Advices of NSW Office of Water below.

1. Water quantity and quality treatment and the protection of downstream environment

## 2. Boardwalk Creek

LANDSCAPE STRATEGY

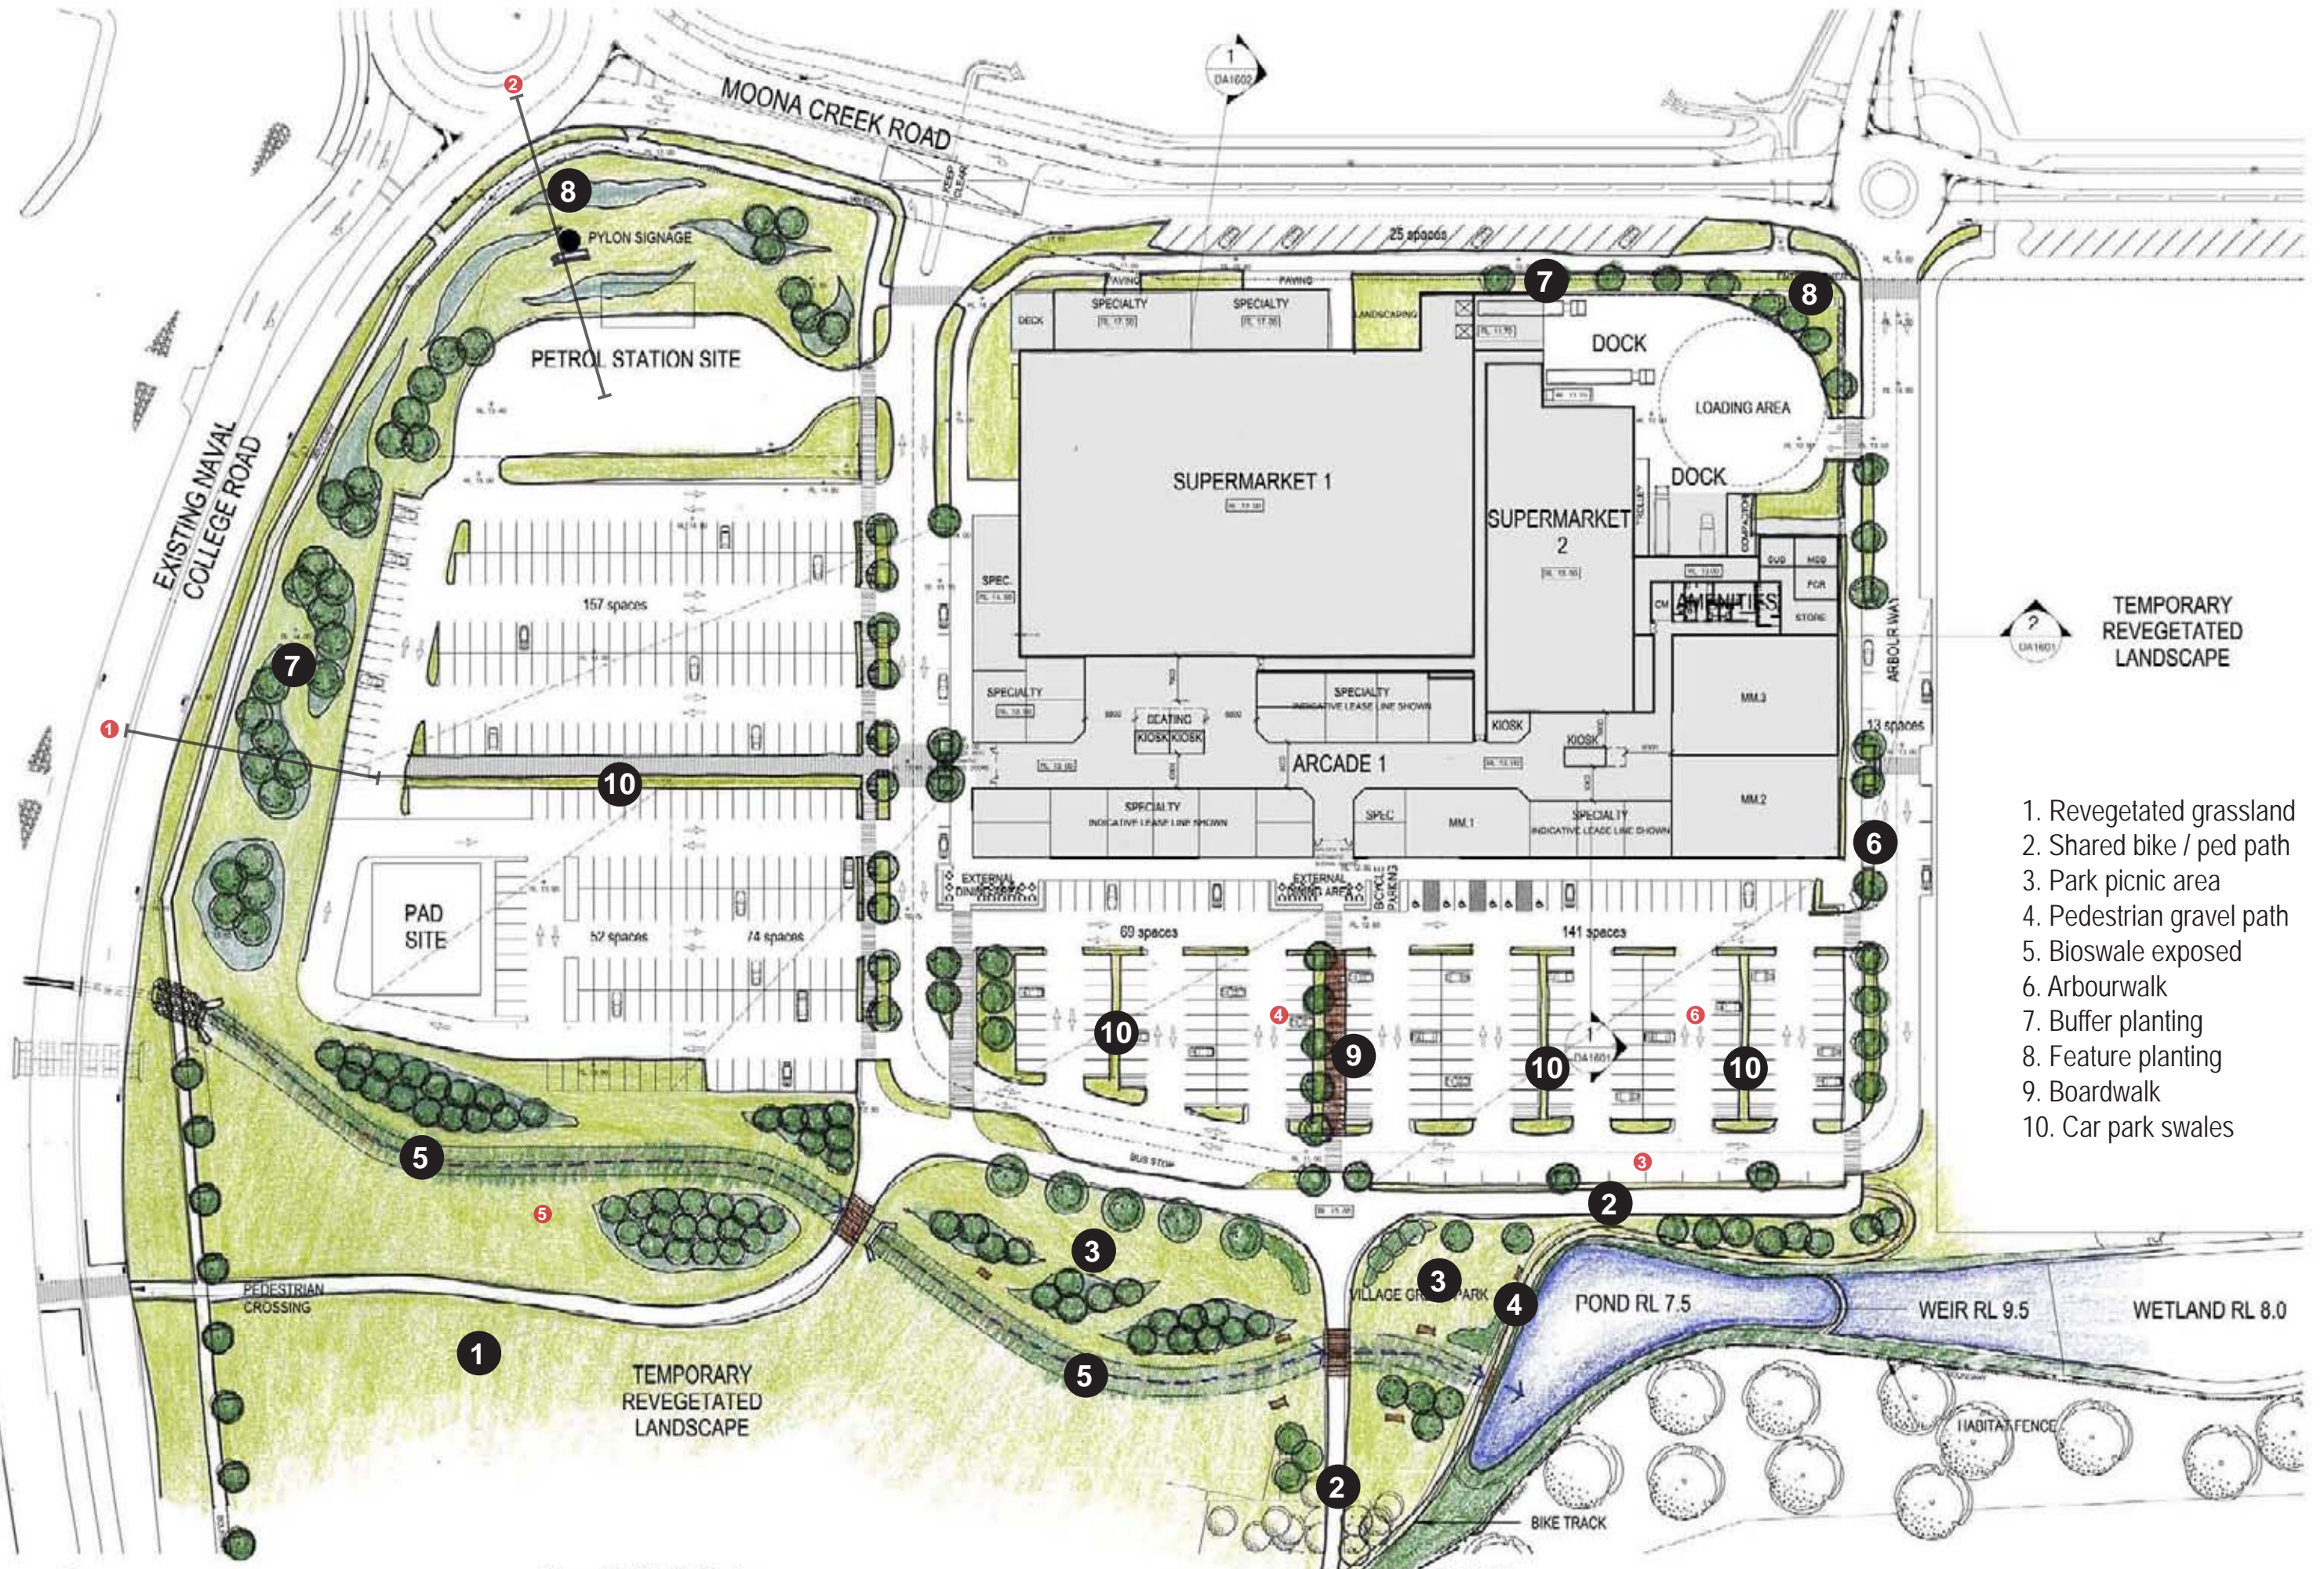
The Amended Statement of Commitments (SOC) (15) indicates the proponent is to undertake further detailed design of the top-up arrangements for the pond to maintain aesthetics during dry periods. The Landscape and Sustainable Design diagram indicates the pond is proposed to be located on-line. It is recommended that management issues relating to blue green algae and aquatic weeds are comprehensively understood to ensure the downstream SEPP 14 wetlands are adequately protected.

Clarification is required on the proposed treatment of "Boardwalk Creek". Based on the information provided in the current Modification application it is unclear if Boardwalk Creek is still proposed to be piped, or if is now proposed to remain as an open system, for example:

- ☐ ☐ ☐ ☐ the Architectural Design Statement indicates the character of the landscaped creeks and trees will not be adversely impacted by the proposed modification (page 4).
- ☐ ☐ ☐ ☐ the Landscape and Sustainable Design diagram shows the location of Boardwalk Creek.
- ☐ ☐ ☐ ☐ the Proposed Connectivity and Vincentia District Centre diagrams show a boardwalk / car park is proposed to be located over Boardwalk Creek.
- ☐ ☐ ☐ ☐ the Amended Statement of Commitments (SOC) (13) refers to the design of the drainage channel in the location of Eastern Creek with the design of Stage 1A including detailed designs of the piped drainage system (page 3).
- ☐ ☐ ☐ ☐ the Design Statement refers to "reopening the creek to the sky" (see point (g) under boardwalk on page 14).

If Boardwalk Creek is to remain open, it is recommended:

- ☐ ☐ ☐ ☐ it is rehabilitated to mimic a stable natural creek system from the local area,
- ☐ ☐ ☐ ☐ a vegetated riparian corridor is established along either side of Boardwalk Creek, and
- ☐ ☐ ☐ ☐ the riparian corridor is planted with native plant species from the local vegetation community;
